30 September 2018

**Attention: Director – Industry Assessments**

# Objection to the proposed Rushes Creek Poultry Production Farm State Significant Development 7704

Figure 1: Site Plan(s)

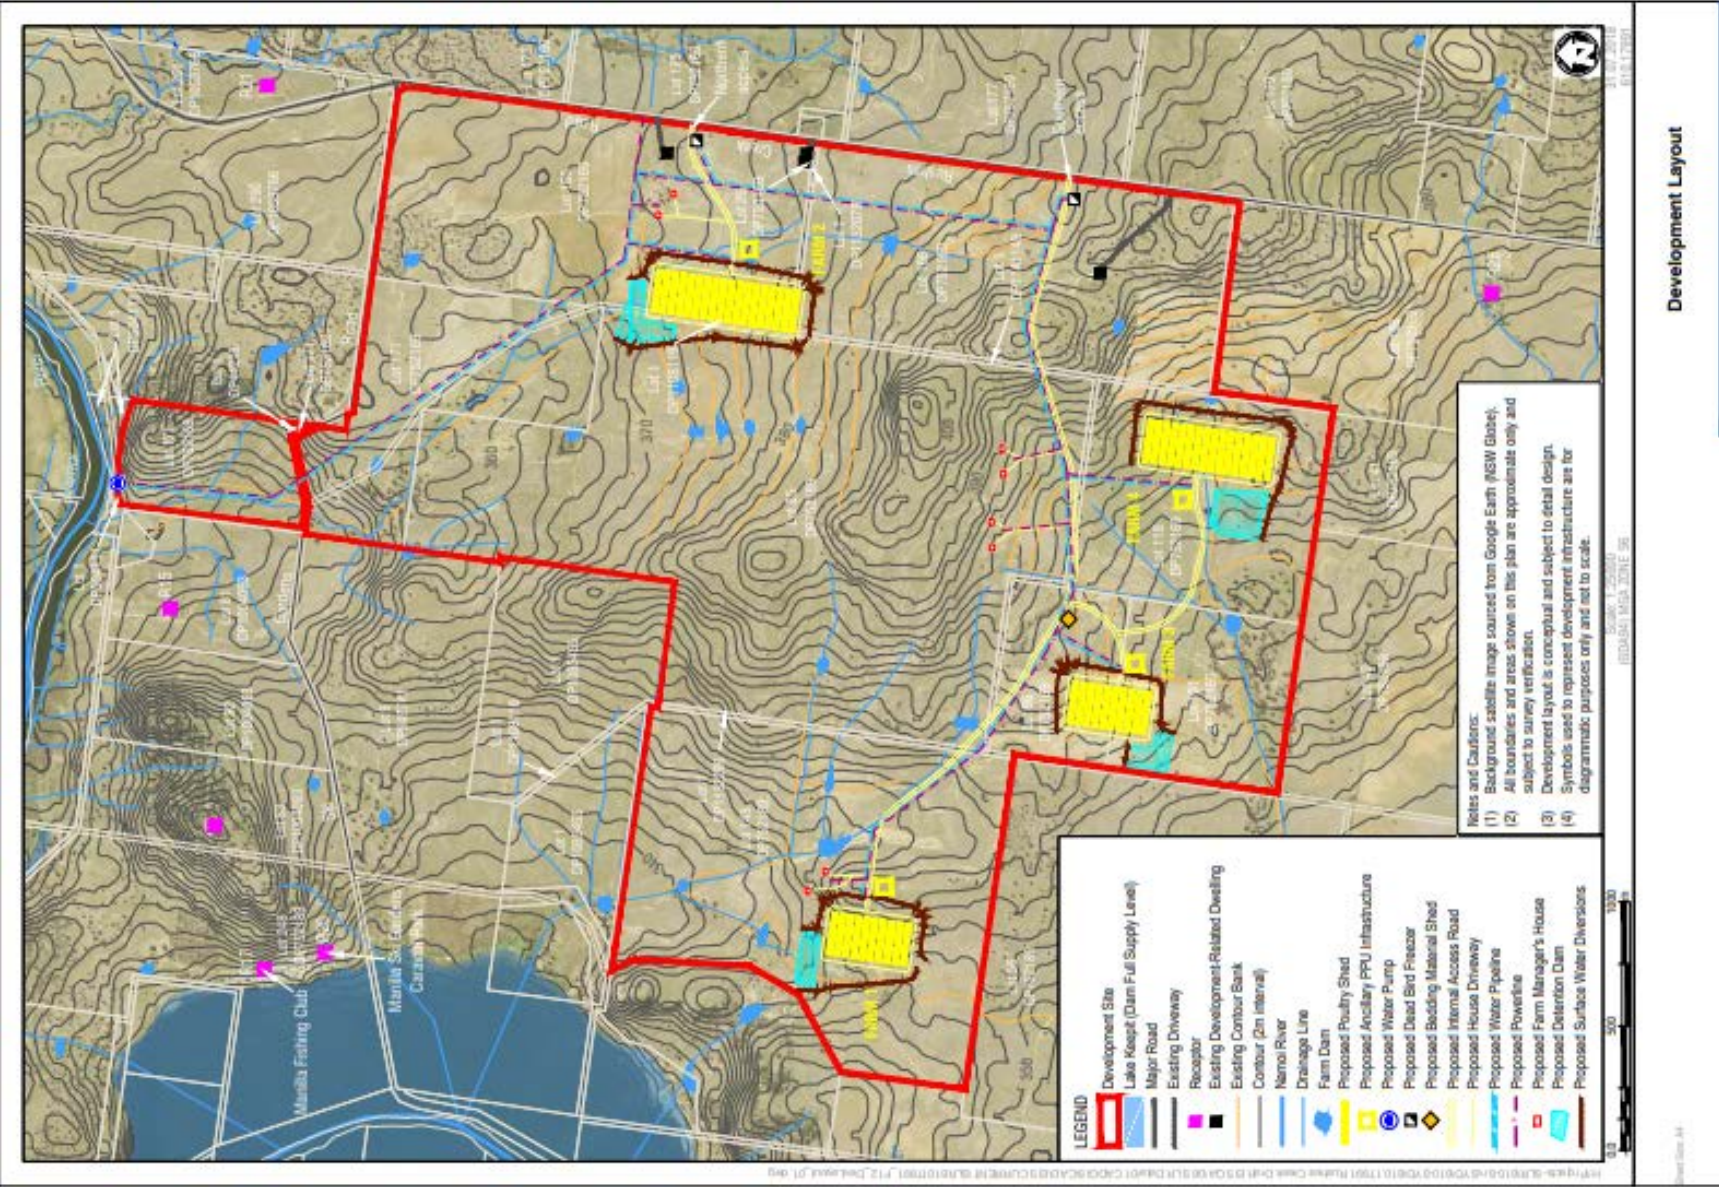
My home is located only 1,025 metres from Farm 4 of the proposed development. The requirements of the NSW Department of Primary Industries (DPI) and the NSW Office of Environment and Heritage (OEH) have not been met. The proposed development does not have an adequate separation distance from my residence and therefore cannot be permitted to proceed.

Therefore **the allowable number of meat chicken sheds that will house 56,500 birds at a separation distance of 1,025 metres from my home is 3.7**. So the 16 sheds proposed by the proponent in farm 4 are not permissible under the guidelines set down by the NSW DPI and the NSW OEH.

Therefore **the separation distance required for a 16 shed broiler poultry farm that will house 904,000 birds is 2,895 metres from my home**. So the 16 sheds proposed by the proponent are not permissible under the guidelines set down by the NSW DPI and the NSW OEH.

The proposed development will see 1 farm (farm 4) built within 125 metres of our boundary and a second farm (farm 3) built within a very close proximity to our boundary. One of these farms (farm 3) will also be located within 125 metres of the boundary of our neighbour's

The proponent of this development has purchased 1200Ha of land. That’s 12 square kilometres, yet 2 of the 4 farms proposed are to be built, will be within 100 to 125m of the boundaries of the 2 adjoining properties on the southern side of the proposed development site (why??). Given the size of the proposed development, surely the local LEP would require a much greater setback (buffer zone) than just 100 to 125 metres from the adjoining properties. This is also the view that has been expressed by two current Councillors from, Tamworth Regional Council that I have spoken too regarding this proposed development. It should be noted that farm 4 will occupy an area of approximately 20Ha, that’s a massive shed complex.

The councils LEP would most certainly have requirements as to the setbacks (buffer zones) from adjoining properties, for new developments. To only have a 100 to 125 metre setback from my boundary, for a development that occupies 20Ha, would not and should not be permitted by the planning requirements of the Tamworth LEP.
